RE: 5100 Kanata Ave TIS Circulation Comments
("Kanata Lakes Plaza TIS")

Dillon produced the Kanata Lakes Plaza TIS dated October 6, 2017. The City of Ottawa commented on the TIS on October 30, 2017. This letter responds to each of the City's comments.

The October 6, 2017 City comments are listed below. Dillon's responses are indicated in bold following each of the City's comment.

Figure 1: Proposed Site Plan

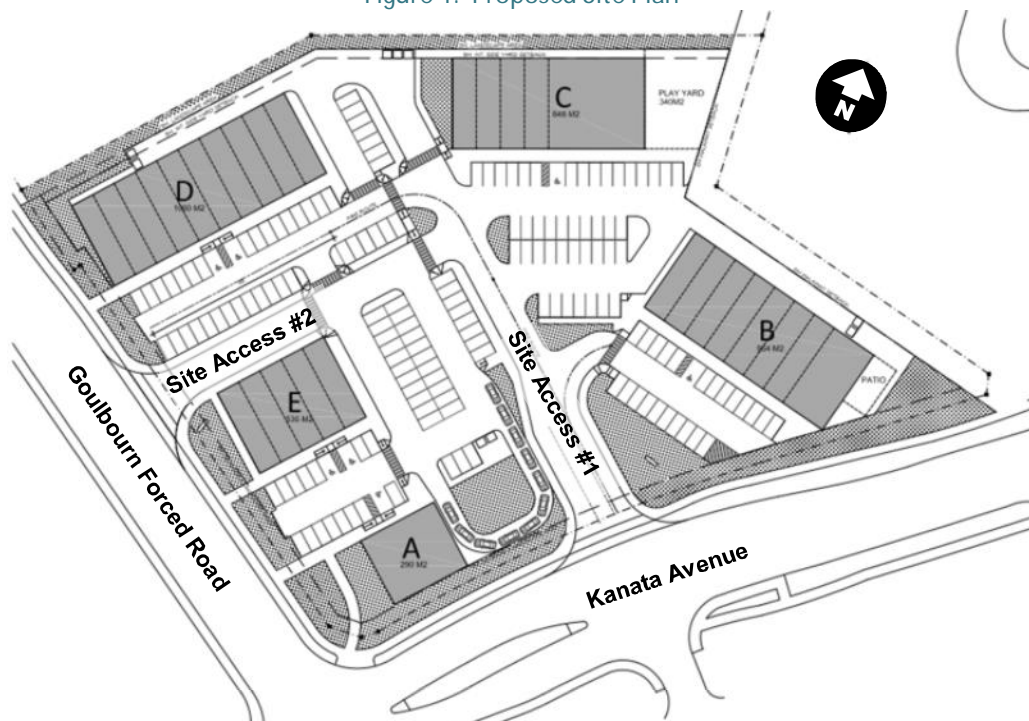
5. A separate site plan was not provided and dimensions were not illustrated in the report. Ensure that both site accesses are restricted to 9m in width. It is also recommended that only one lane in and one lane out be provided at Access #1.

Dillon Response – Acknowledged. See revised site plan submission drawings.

Figure 7: 2023 Assumed Traffic Control and Intersection Geometry

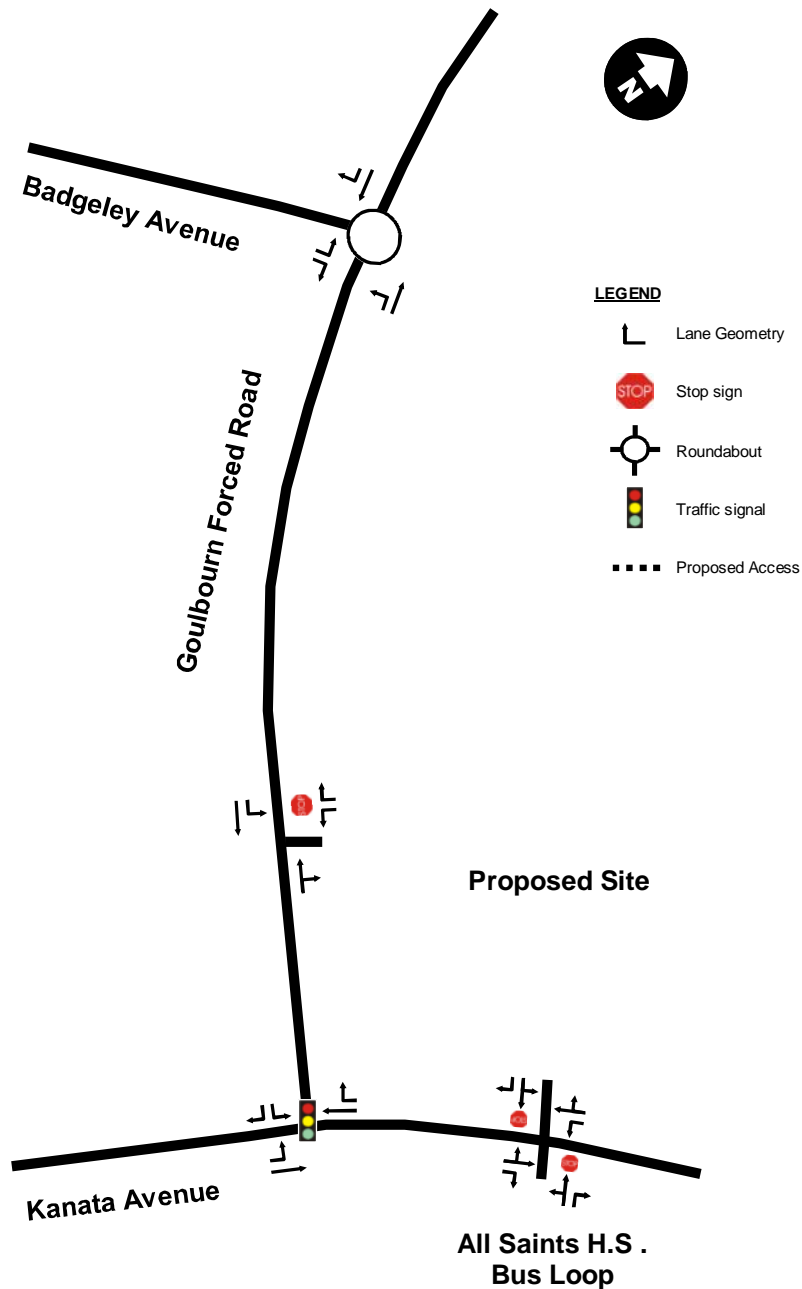
3. Due to the proximity of the school access and the signalized intersection to the proposed site, it is recommended that the eastbound left-turn at the site access on Kanata Avenue (Access #1) be banned. However, if provision of a left turn lane were constructed within the median space and appropriate pavement markings were provided on Kanata Avenue, the concern for safe movement through this stretch of Kanata Avenue would be reduced.

Dillon Response – KNL Developments has decided to eliminate the eastbound left turn lane request and has modified the proposal to include a Right In/Out, Left Out only island (restricting eastbound left turns) to the site.
